# Rezoning Transportation Analysis

Petition Number: 2023-164

Date	Description
1-24-24	First Review (JP)

DRAWING NO.: **RZ-01**

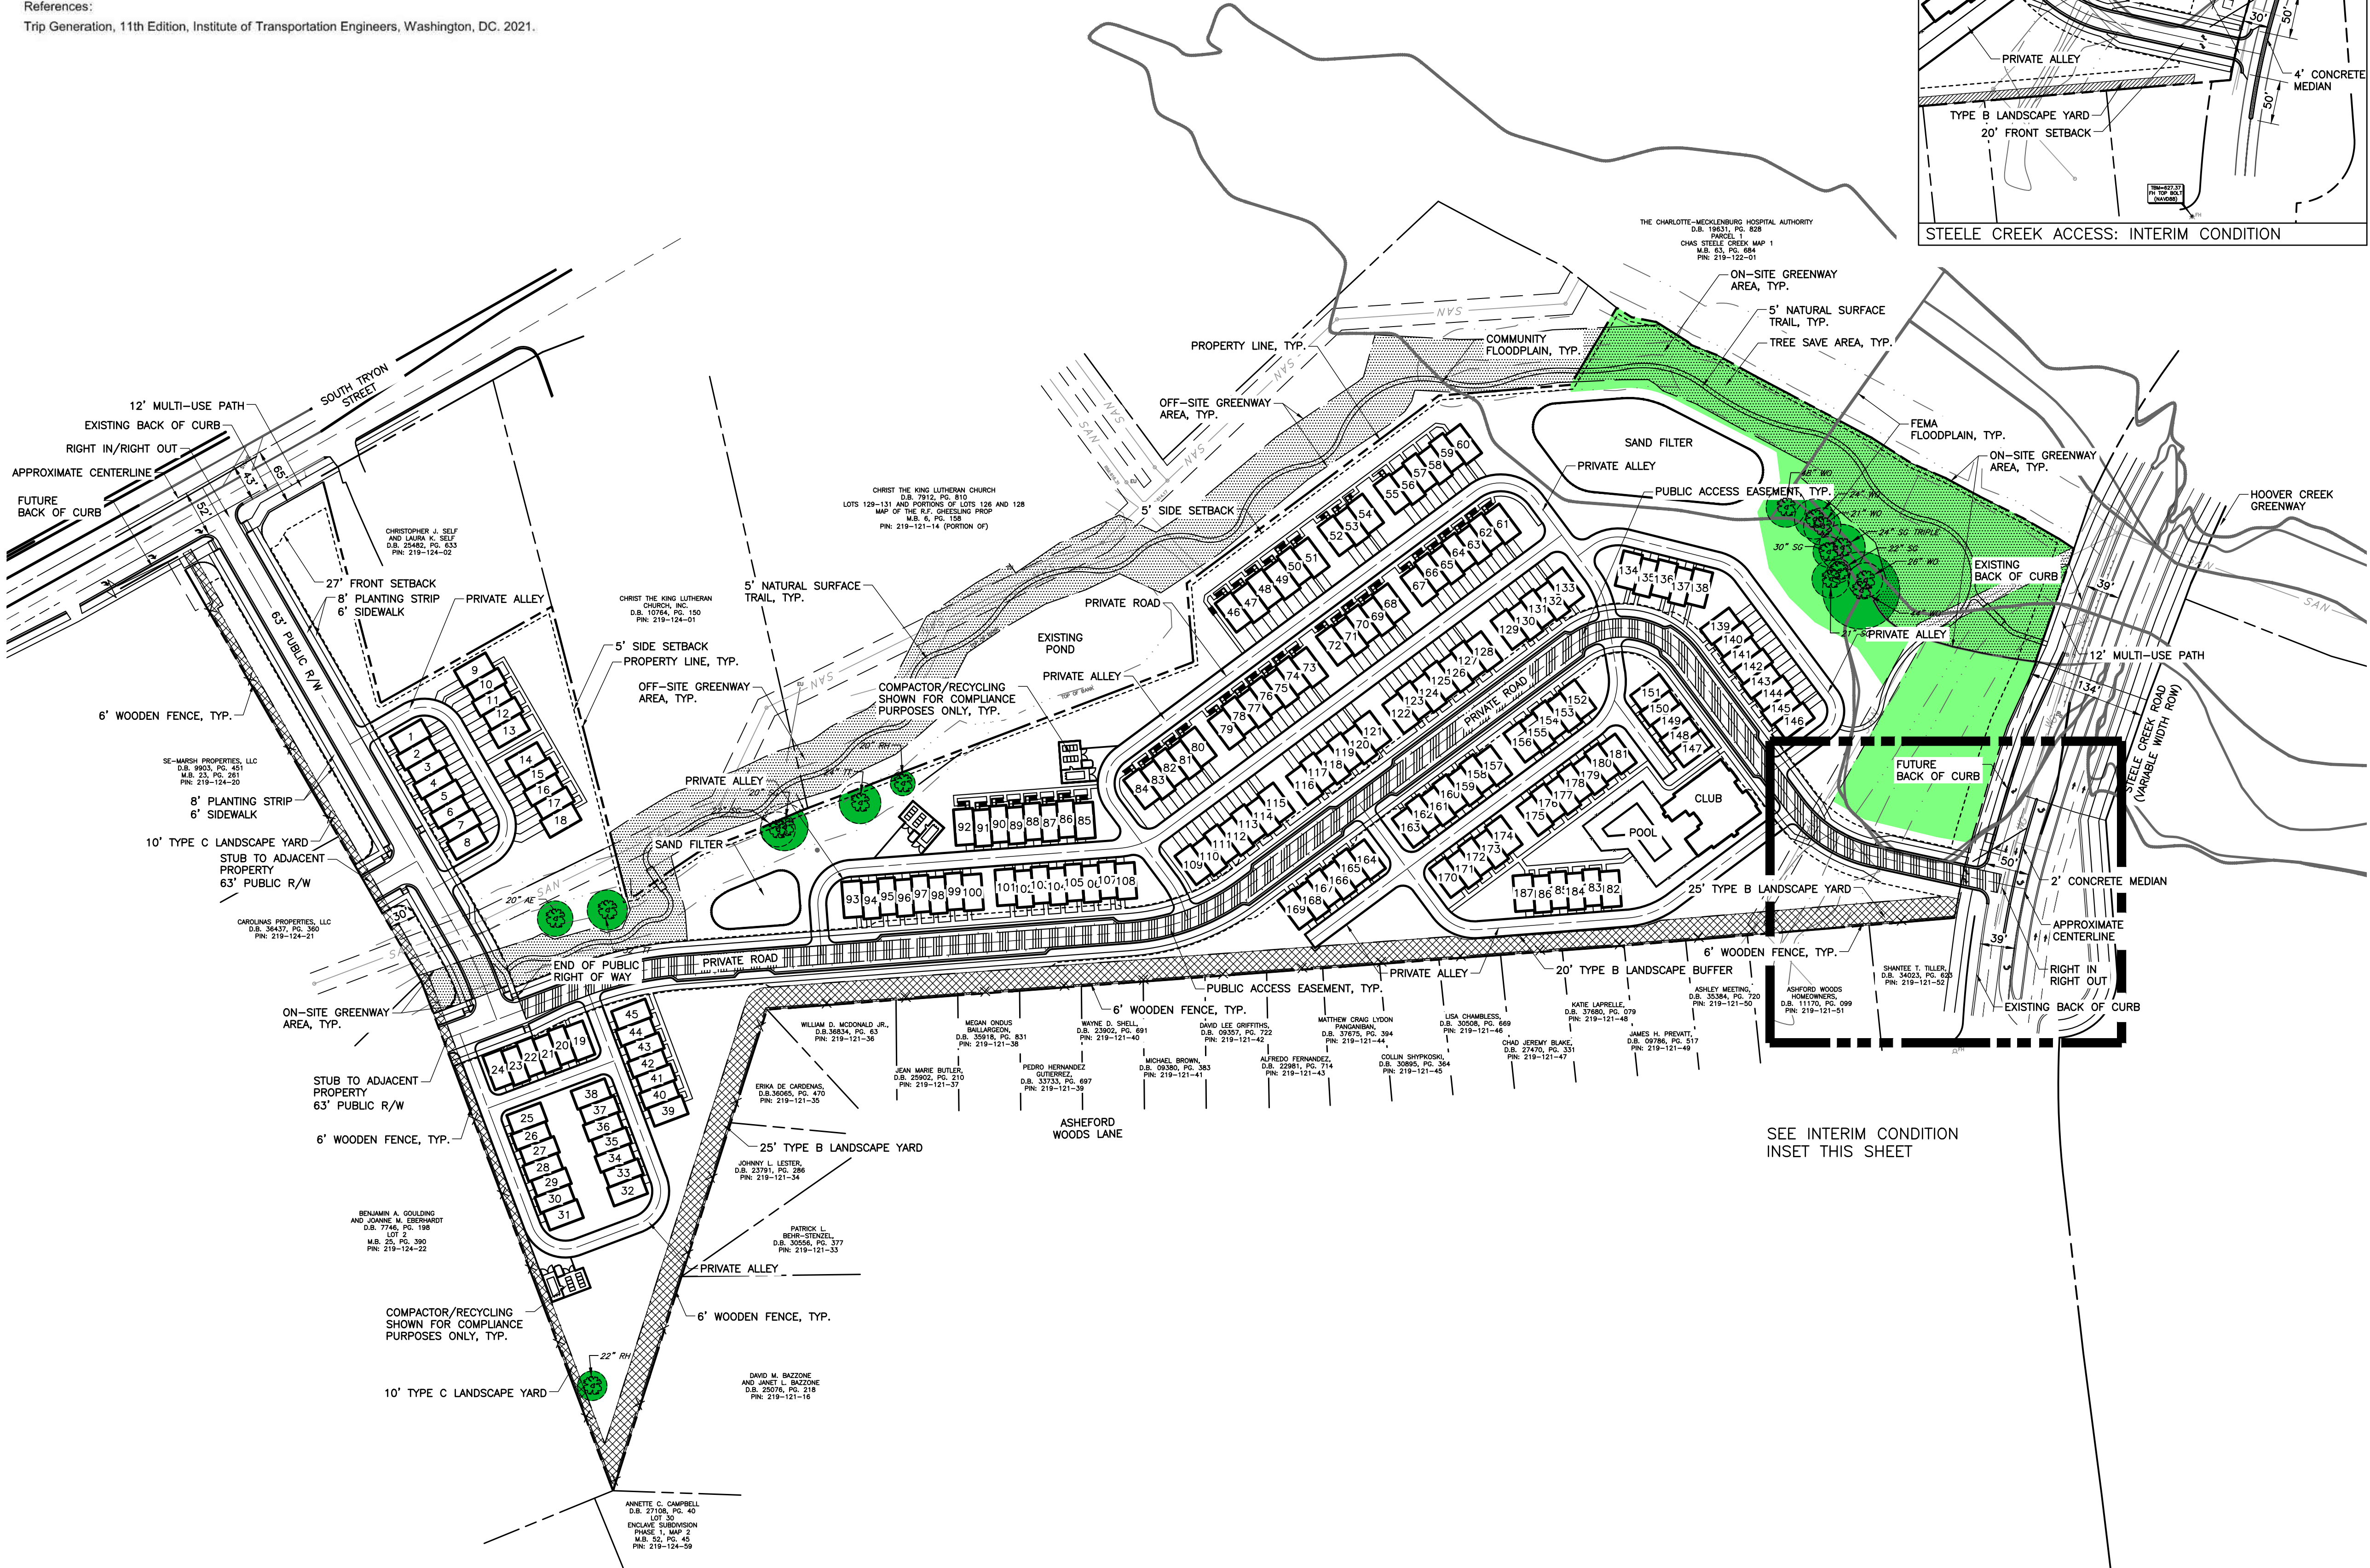
- a. **Tryon Street:** The future location of curb and gutter is in its existing location.
- b. **Steele Creek Road:** The Streets Map location for curb and gutter is 33' from the centerline for a 4+ boulevard with a 12' shared use path.
- c. **Proposed Public Street:** Face of curb to be located 15' from the centerline. CLDSM U-03A2

Label and dimension the curb and gutter from the centerline for each road on the site plan.

5. Revise site plan to shift Tryon Street access further from existing driveway.

6. Revise site plan and conditional note(s) to commit to construct bicycle facilities by installing a 12' multi-use path on Tryon Street in accordance with the council-adopted Charlotte Streets Map. Multi-use paths maintained by the City shall meet ADA/PROWAG requirements.

8. Revise site plan and conditional note(s) to commit to provide a public access easement for the Private Road (UDO 31.1 (A)(1)).
9. Add a conditional note specifying "the Petitioner shall dedicate and convey in fee simple all rights-of-way to the City before the site's first building certificate of occupancy is issued. CDOT requests rights-of-way set at 2' behind back of sidewalk where feasible."
